Planning application: 2020/92067

**FORMER STILE COMMON INFANT AND NURSERY SCHOOL,
PLANE STREET, NEWSOME, HUDDERSFIELD, HD4 6DF**

ERECTION OF 30 DWELLINGS

COMMENTS OF

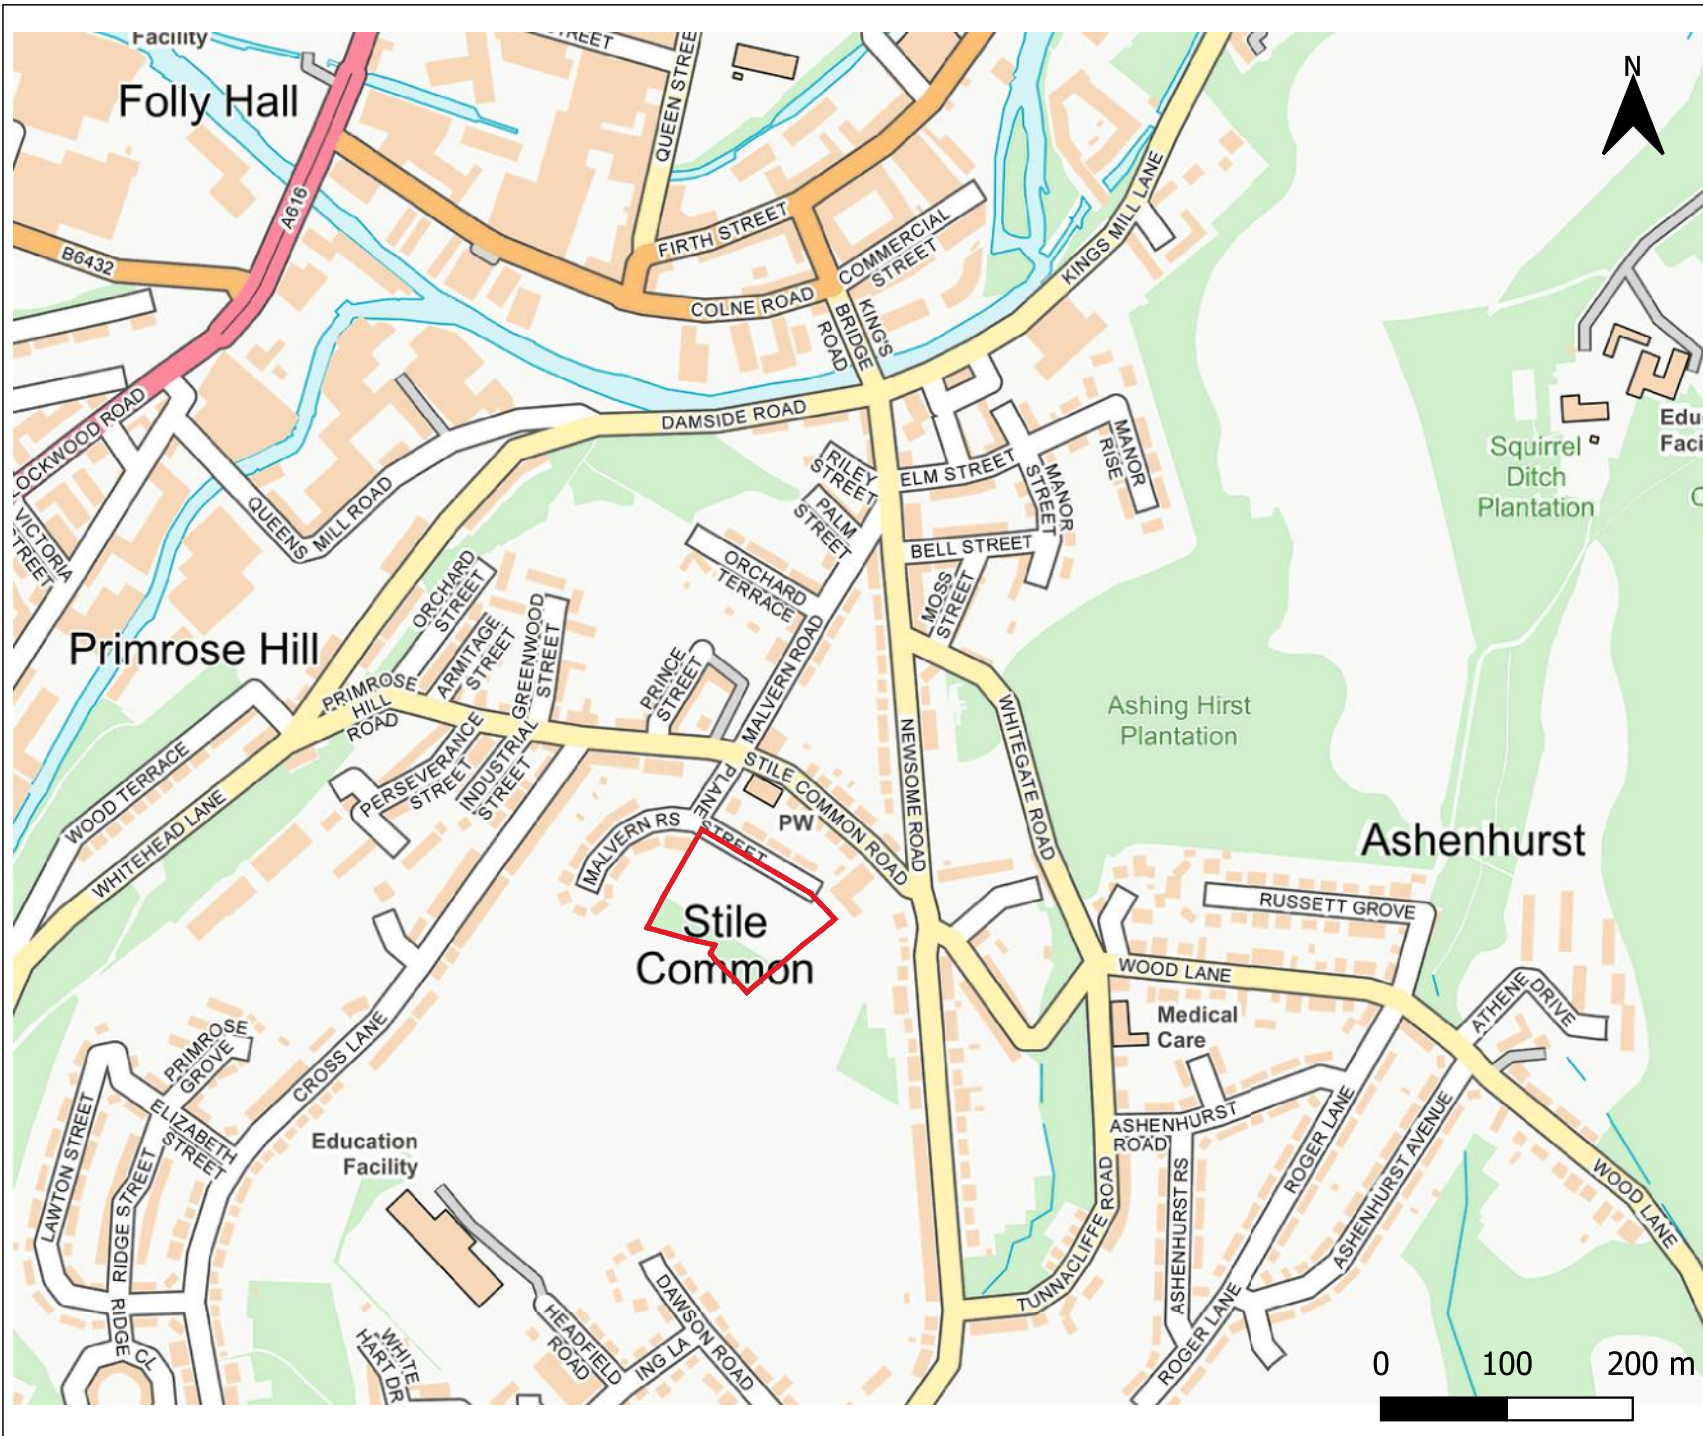
If I have correctly read what appears as an inset on a drainage plan, there is put forward a plan to construct off-site pipework all the way to a culvert in Newsome Road "if considered feasible".

Into new drainage pipework, but not shown on plan, there would also need to be drains to take surface water from the extended Plane Street and the foot of the south-eastern side of the new access.

It is disturbing to read, however, that there is an 'Alternative (Fallback) Surface Water Discharge Strategy', which I feel would not be a reasonable strategy to allow as it would appear that there would not be gravity feed of all run-off water to drains or attenuation tank. The surface of an extended Plane Street would be some 2 metres below the level of the existing end of Plane Street. It would appear that this 'alternative' also closely matches the original intended proposal as discussed with residents when the developer held a consultation meeting.

I note also that there is conflict on the plan between the position of the attenuation tank and the retention of the stone boundary wall of the former school.
